DELEGATED DETAILS DECISION

Report of the Head of Planning, Building Control, Sport & Green Spaces

Address RAF WEST RUSLIP HIGH ROAD ICKENHAM

LBH Ref Nos: **38402/APP/2015/851**

20667_A_D_MAT

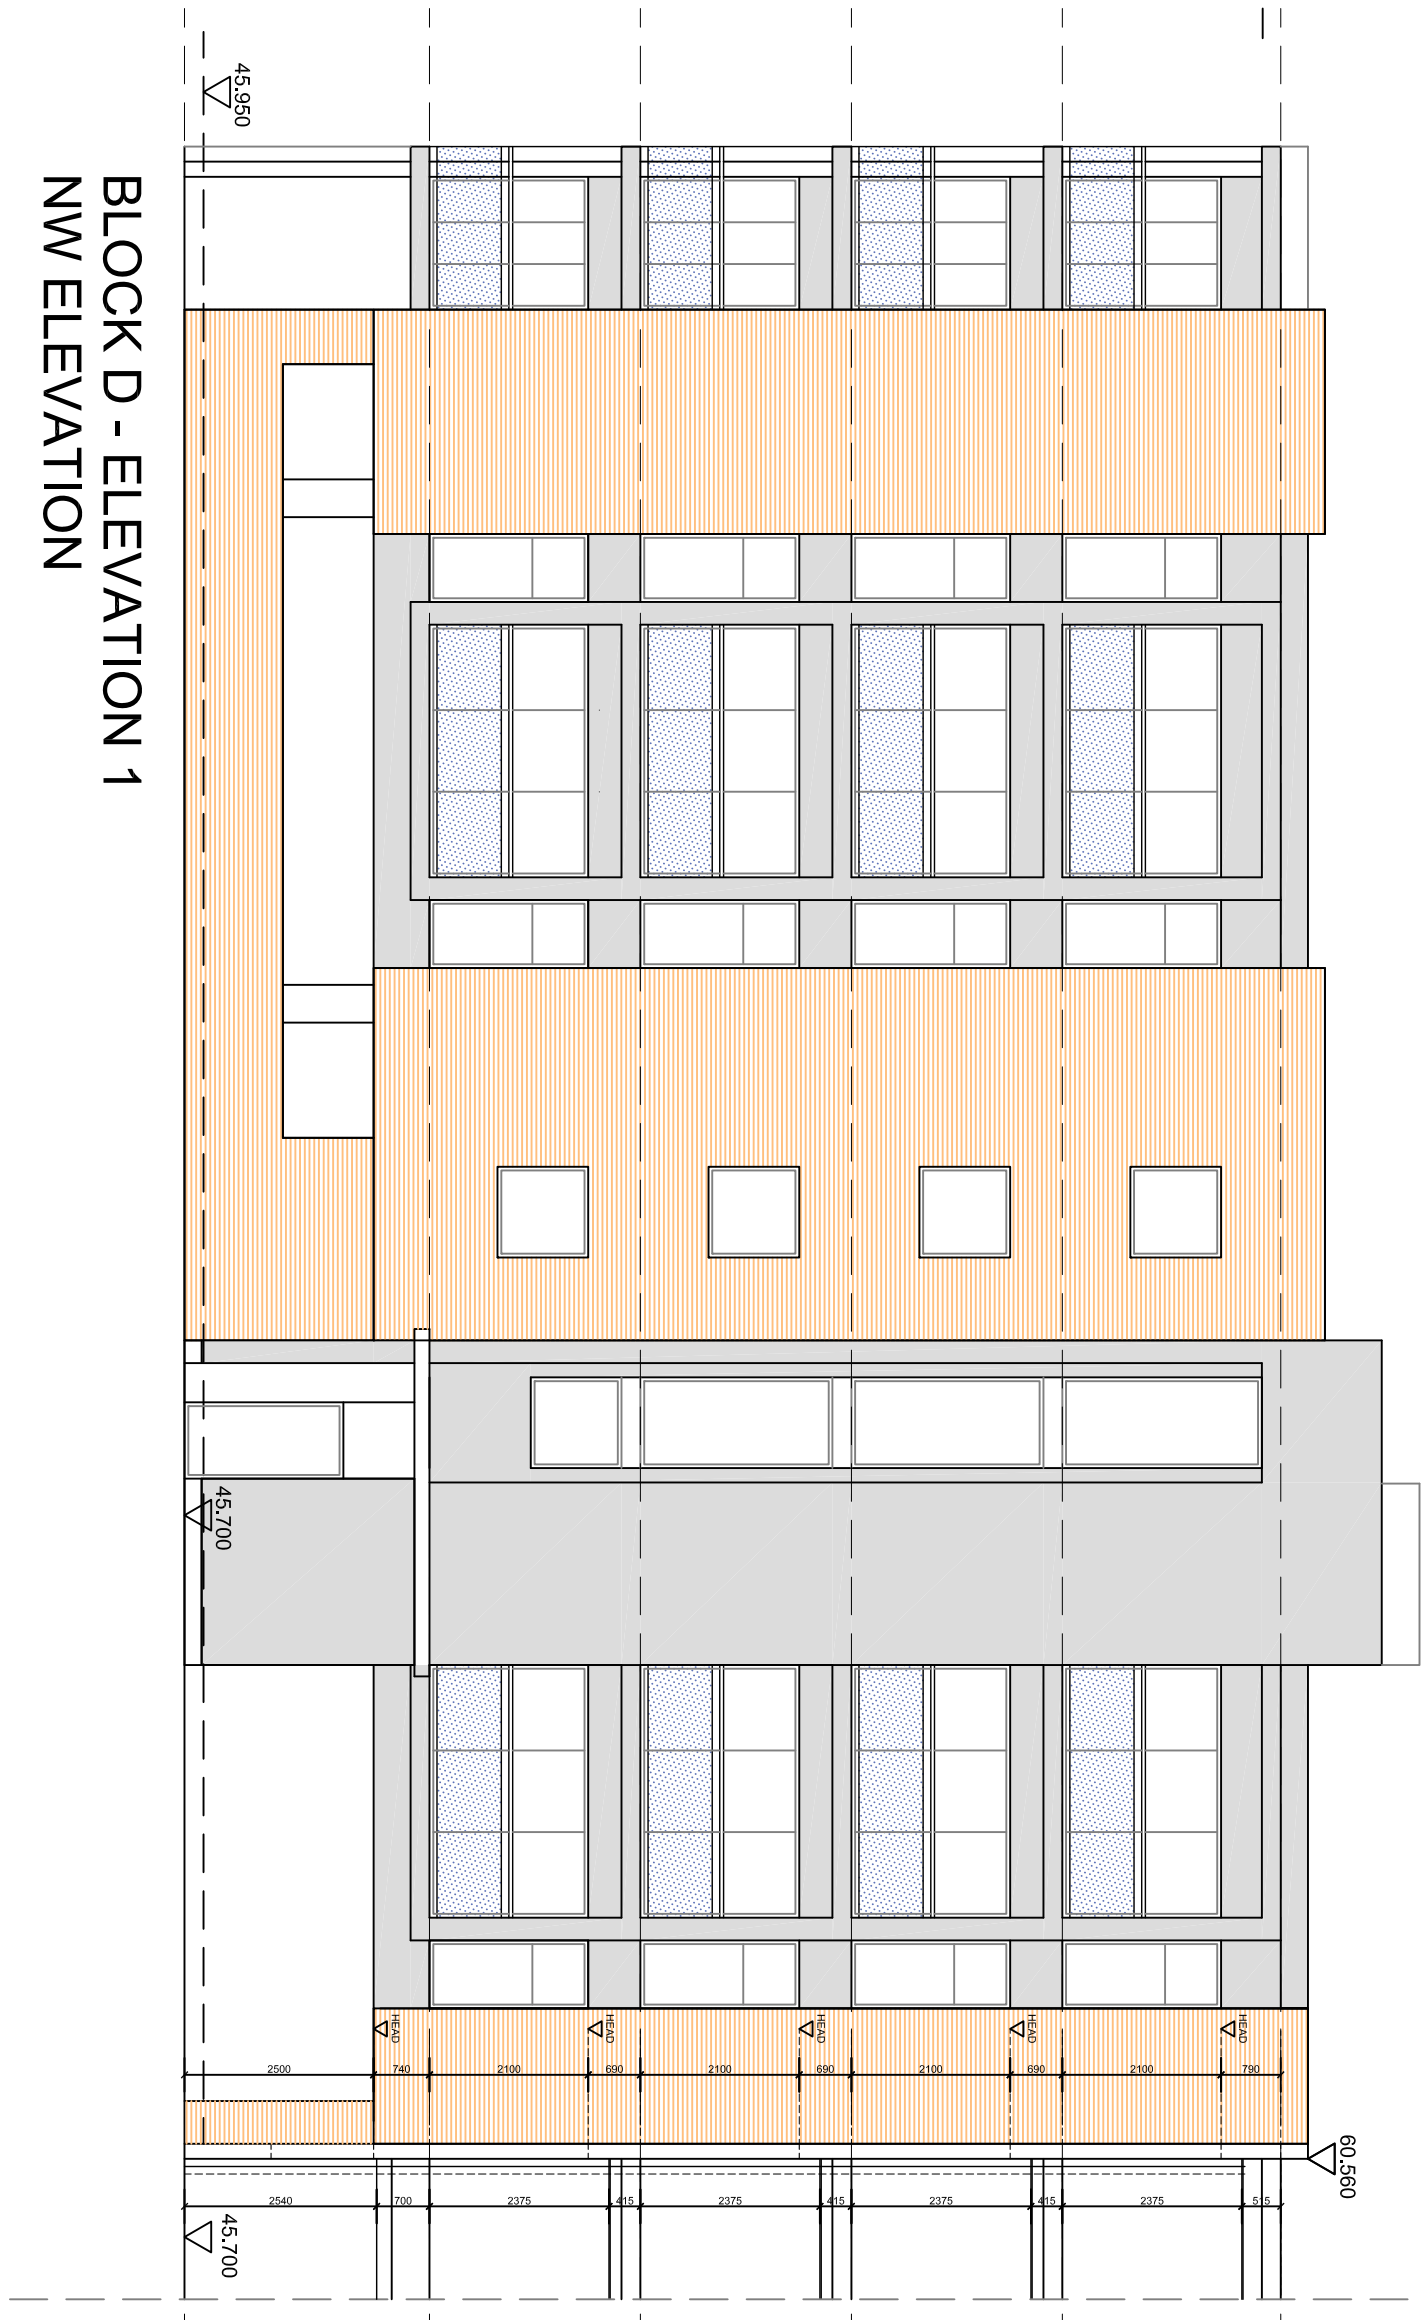
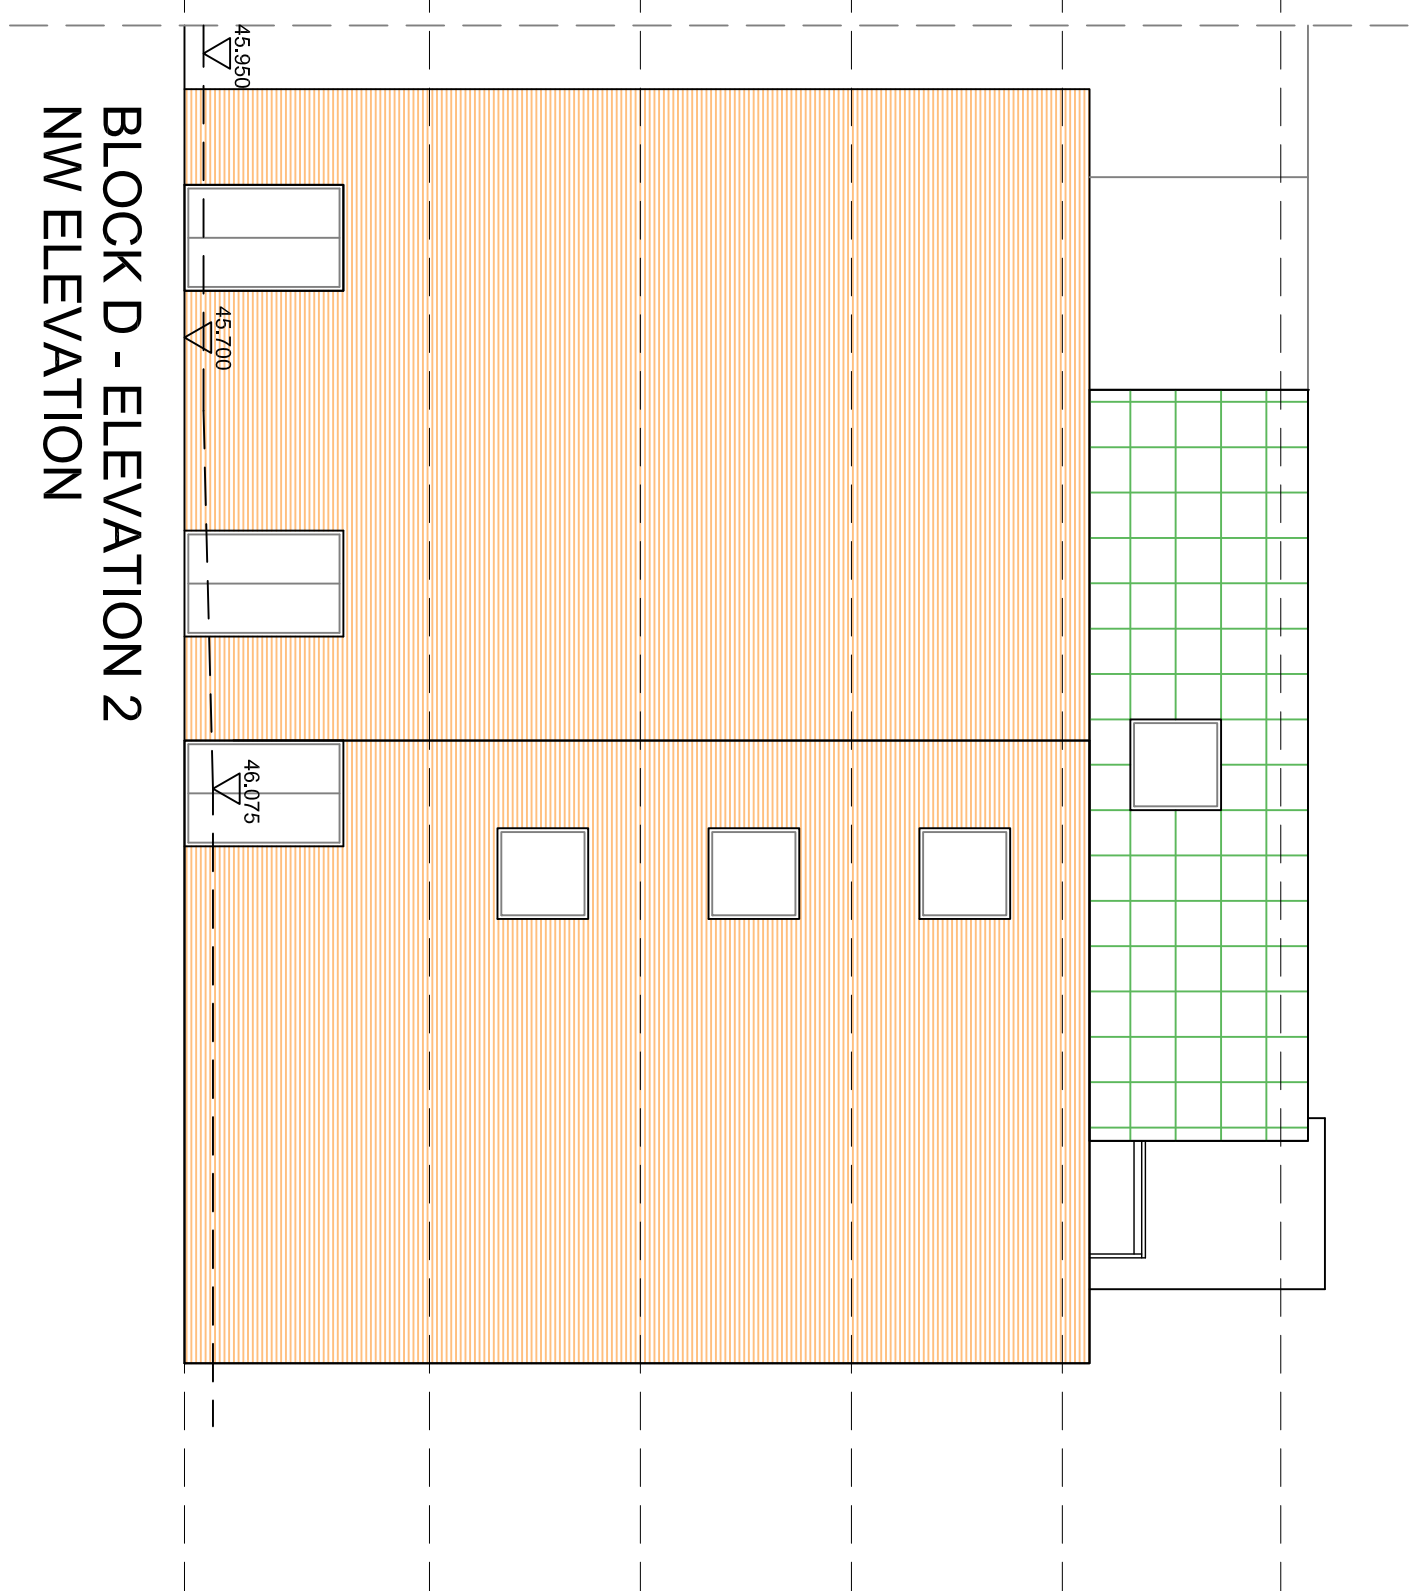
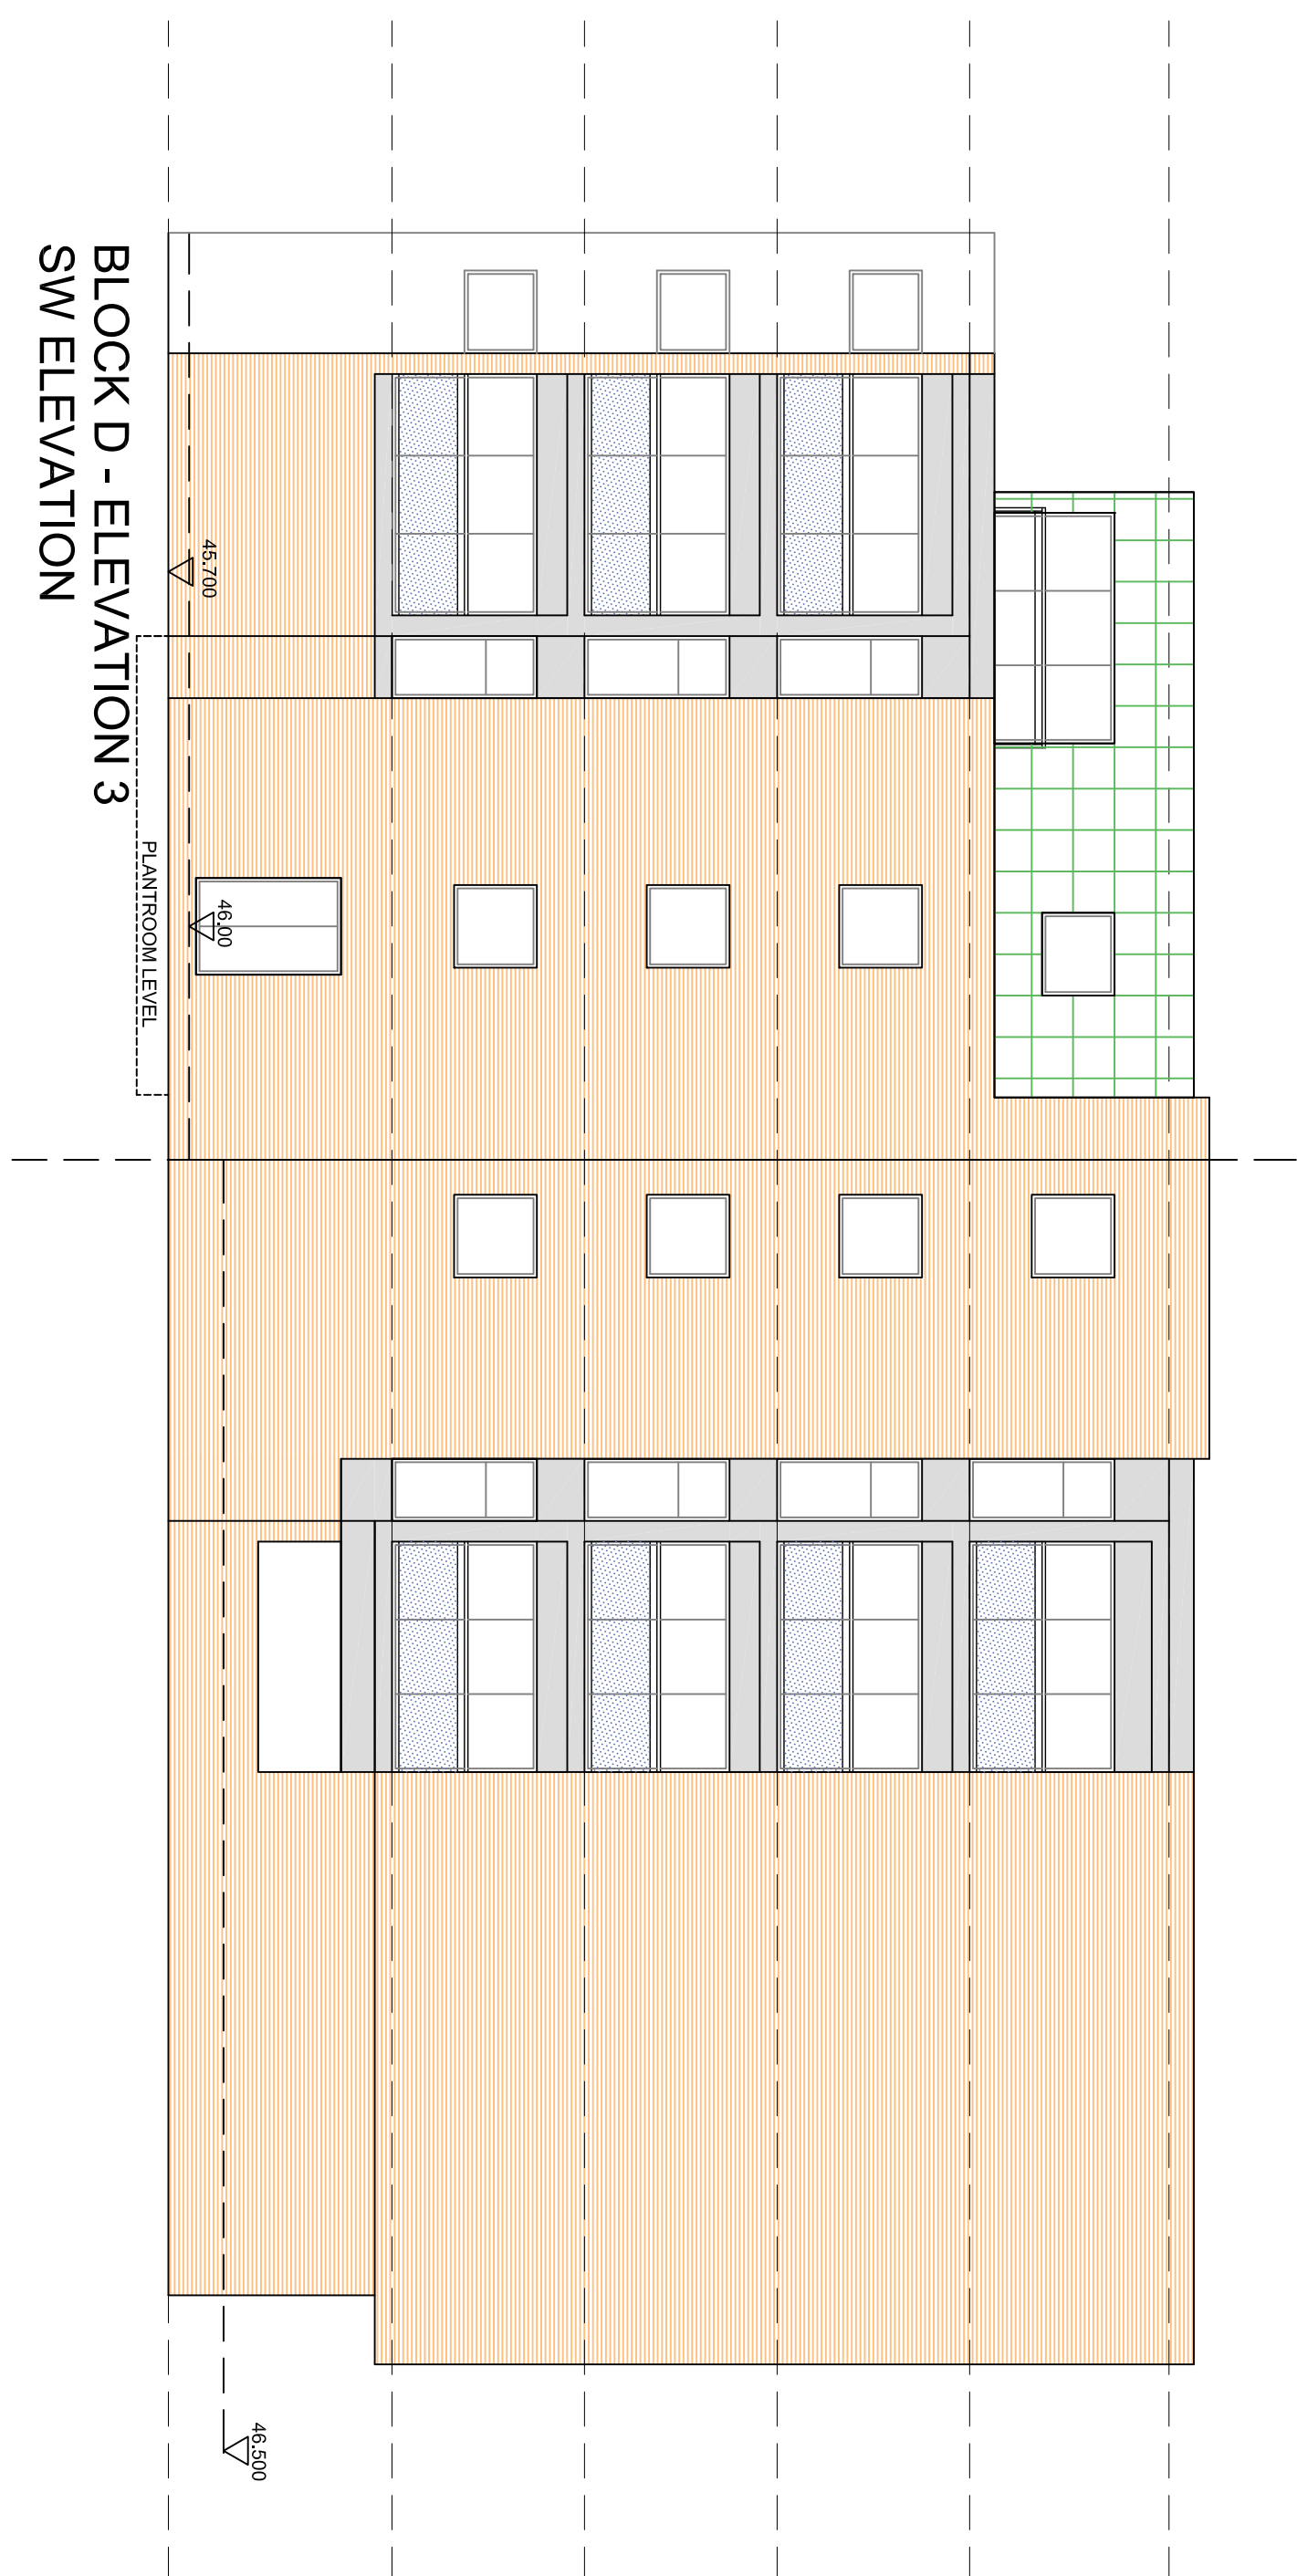
There are, however, concerns re the materials for the two blocks of flats. Whilst these appear to be the same as approved for the existing block adjacent to the

station, this structure as built does now appear to be overly prominent in the street scheme, not only because of its height and bulk but also because of its light coloured rather bland looking materials. If possible, the use of these for this phase should be reconsidered, and a darker more textured brick and a more recessive cladding colour for the upper floor used.

I still think the proposed yellow bricks are not the best, the bricks used on the other side of the site look better, with more texture and a subtle variety in colour. But I don't know how far we can object to the bricks as proposed if we have agreed them for use on this part of the site previously.

The revised proposed brick for use on the flats is acceptable and the other changes to the materials for the houses are also acceptable.

Following the Urban Design/Conservation Officer's initial comments, the bricks for the flatted blocks have been amended and are now slightly more textured. The tiles have been approved previously on the adjoining phases. The agent has also confirmed that the weatherboarding on the projecting bays which are only present on 6 houses would be Eternit Cedral, colour - white. The Urban Design/Conservation Officer is satisfied with the proposed materials.
